Your ref: 3/2018/0036

Date: 1<sup>st</sup> February 2018

**Planning Application 3/2018/0036: Conversion of existing barn to one new dwelling with associated alterations to access incorporating retention of unauthorised new window openings and door, and enlargement of original openings. Manor House, Howgill Lane, Rimington BB7 4EF**

Scale 1:50

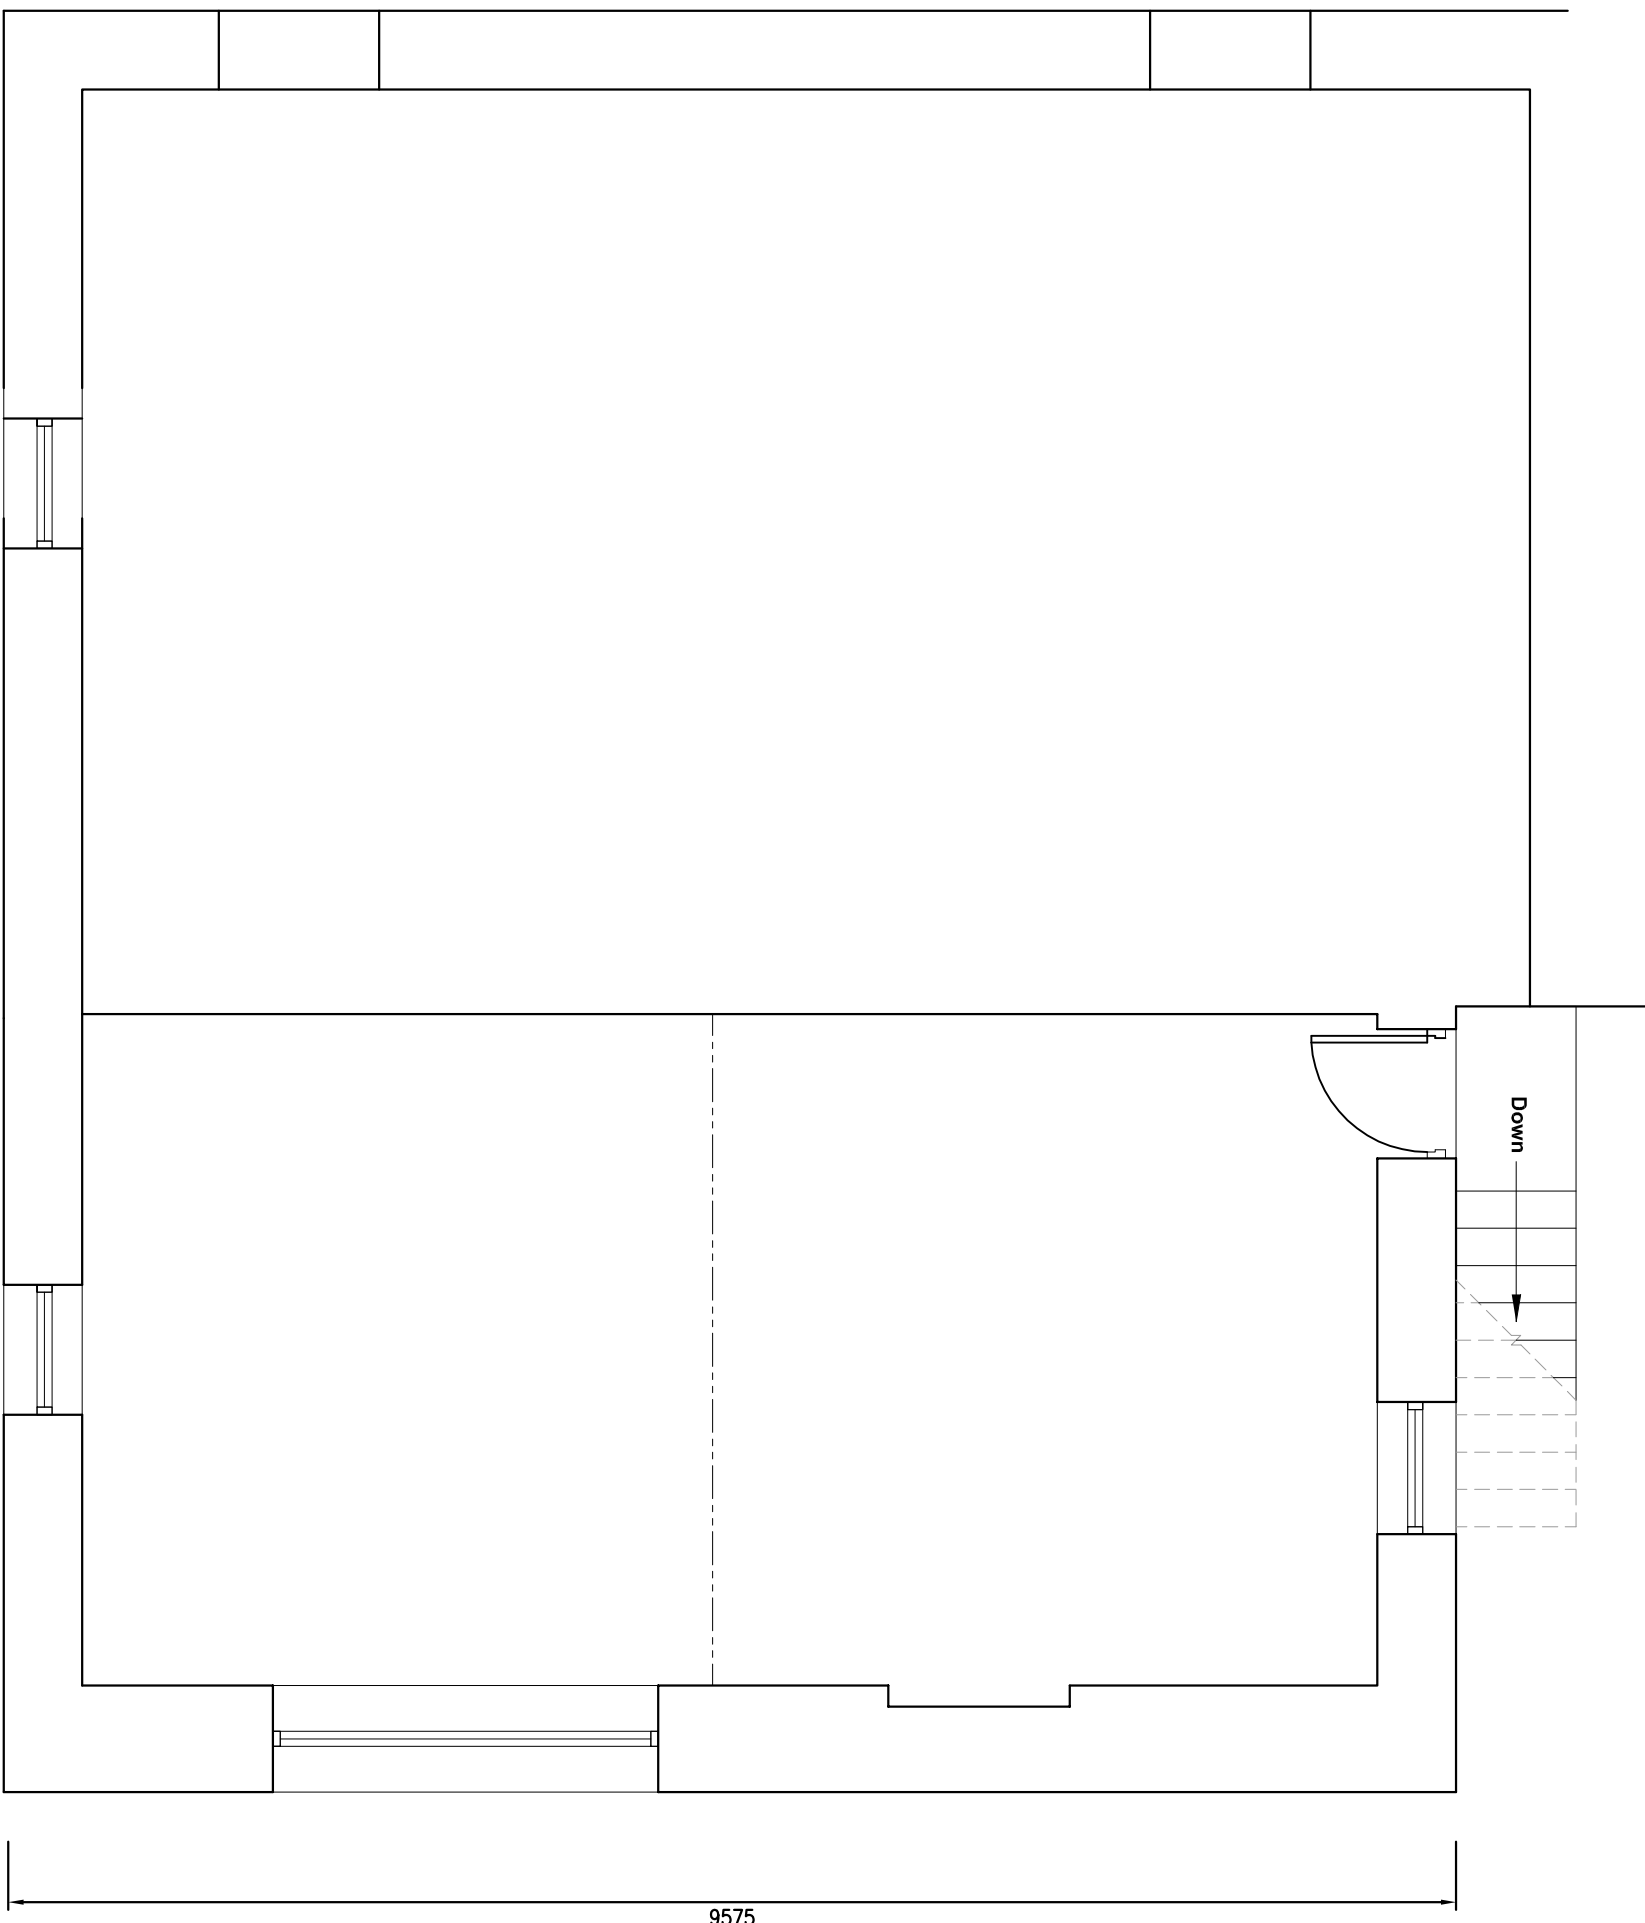
Firstly the description of the proposed works above, taken from the consultation letter, does not match that on the Council's web site nor the wording on the application form. Comparison of the building plans 'as existing' (5364-01) and the photographs of the building contained within the Bat Survey and presumably taken during the reported building inspection of 27<sup>th</sup> March 2017 (BS, p.1) shows a significant number of inconsistencies, not least in the number of doors and windows but also the absence of a dividing wall between the north and south sections of the barn at first floor. It seems likely that the latter is simply a drawing error but the former seem probable to be the 'unauthorised' changes noted above. None of these 'unauthorised' changes are noted on the drawings 'as existing' or 'as proposed' nor is any other evidence provided as to their location, form and extent. As a result it is difficult, if not impossible to come to an informed decision as to their impact on the building.

We would therefore recommend that the applicants are required to submit further information relating to the form of the barn prior to the unauthorised alterations in 2017 and the location and form of those changes, as well as a formal heritage statement describing the significance of the heritage assets here and assessing the impacts of the proposals upon them. This may require field evaluation to assess any buried remains. Without this information, it would not seem possible to provide consent to the current proposals.
